FROM: Ian Gledhill TO: Arun District Council
FAO: Simon Davis

SUBJECT: P/58/15/OUT - Outline application with some matters reserved for the erection of 90 No. dwellings with associated access & open space. This is a Departure from the Development Plan.

Land at, Summer Lane, Pagham, PO21 4NG

Eastern Access - Car (outbound) & Refuse Vehicle (inbound)

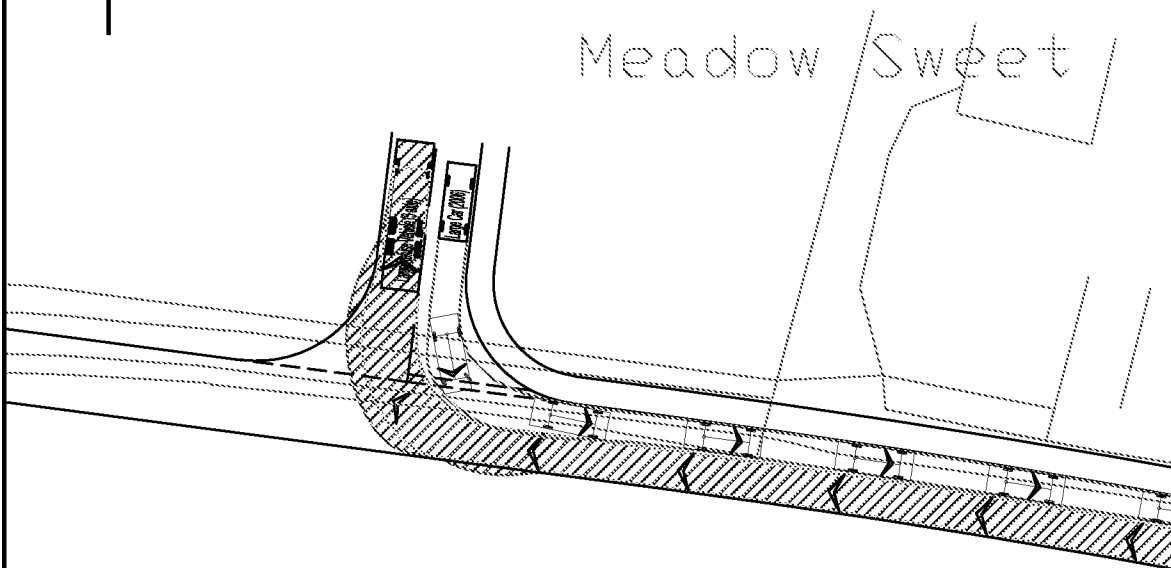
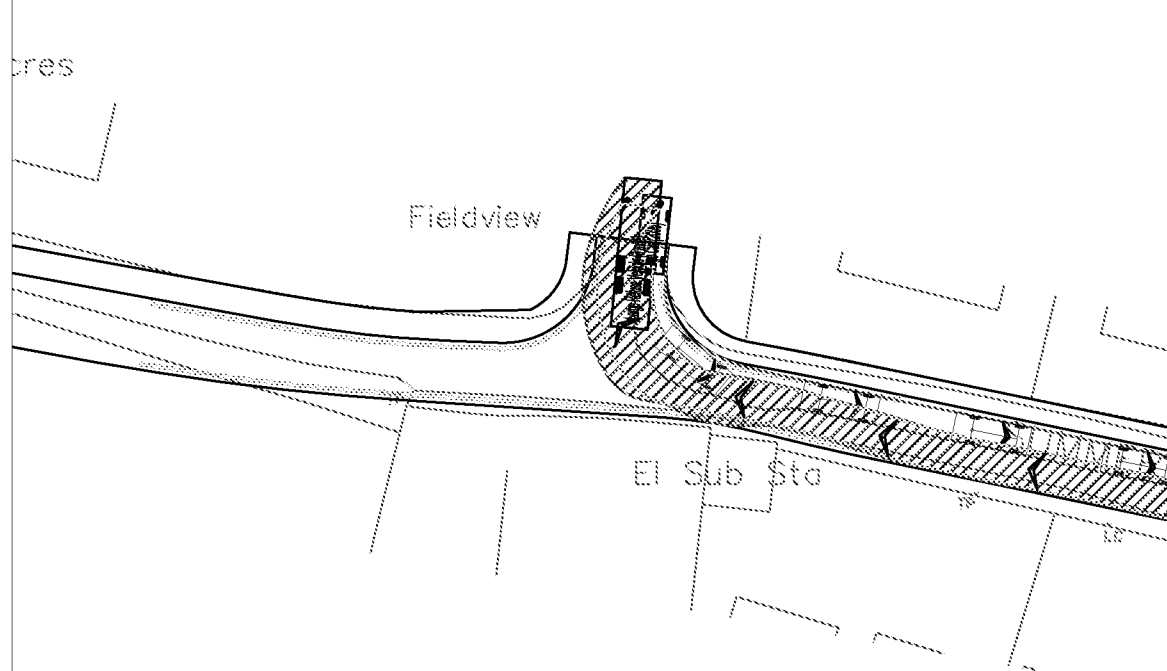
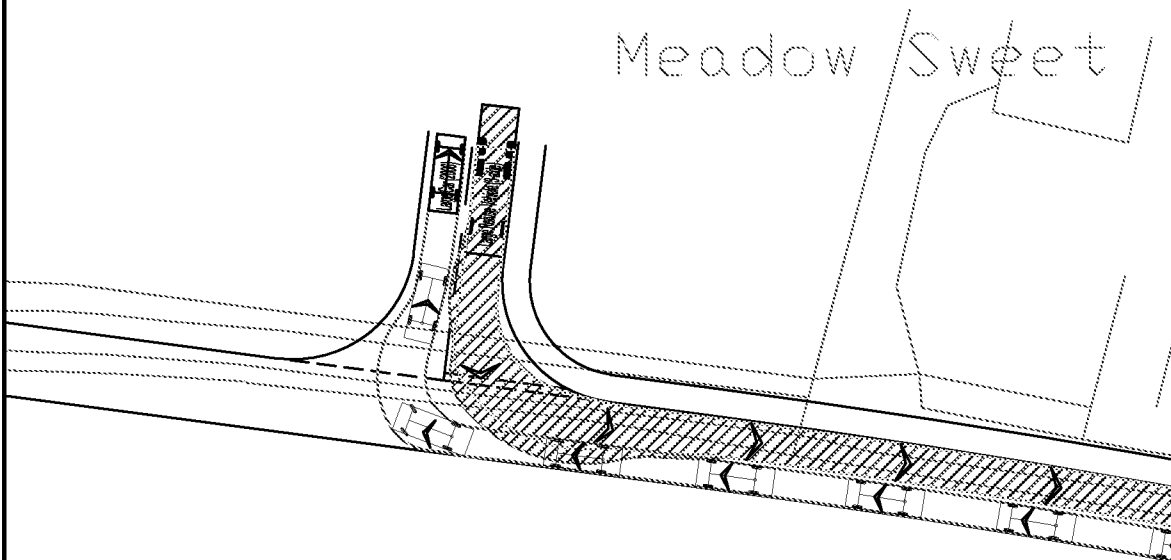
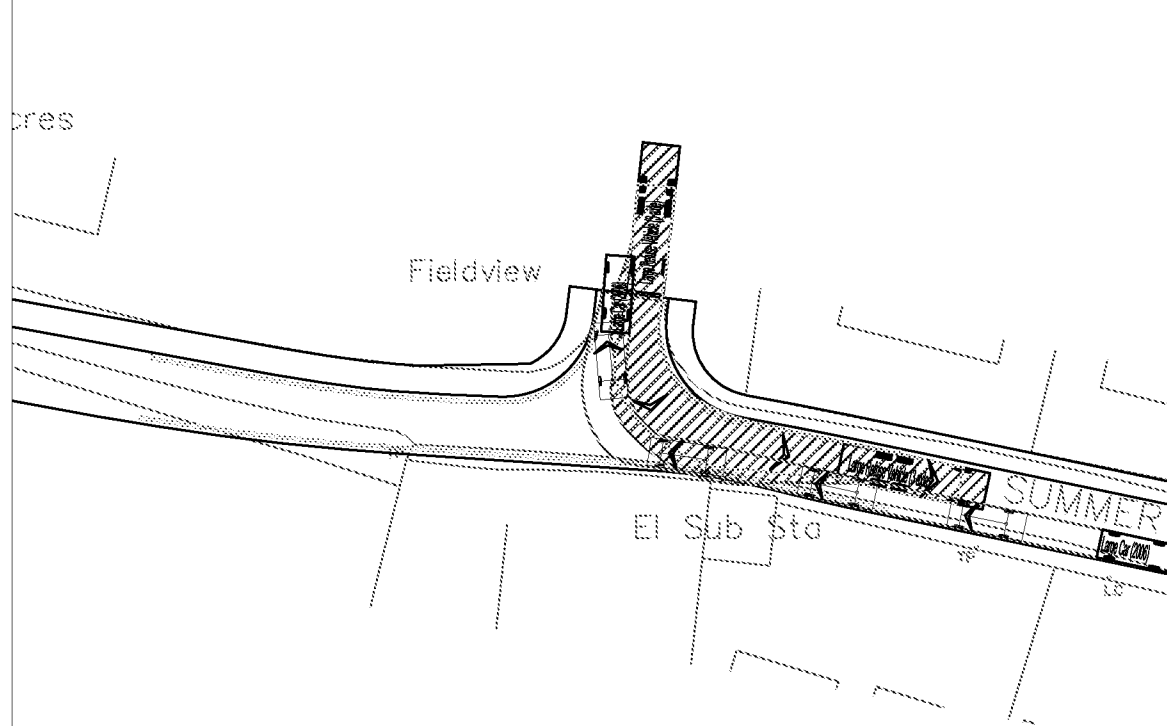
Again at the eastern development access, swept paths have been provided for a refuse vehicle entering and exiting. These show that a refuse vehicle would occupy Summer Lane when turning in or out. This situation is not uncommon at many existing junctions due to the onerous swept path of a refuse vehicle. However the swept paths clearly show that no waiting at any-time restrictions will need to be installed to prevent obstructive parking from taking place. To ensure the restrictions are enforceable these will require a Traffic Regulation Order. The LHA within their initial comments highlighted that due to the requirement for public consultation no guarantee can be offered that the TRO will be made. There is consequently an element of risk.

Given that the eastern access is dependent upon the TRO, this process would need to be completed prior to development commencing. In the event that the TRO failed, alternate measures may then need to be considered.
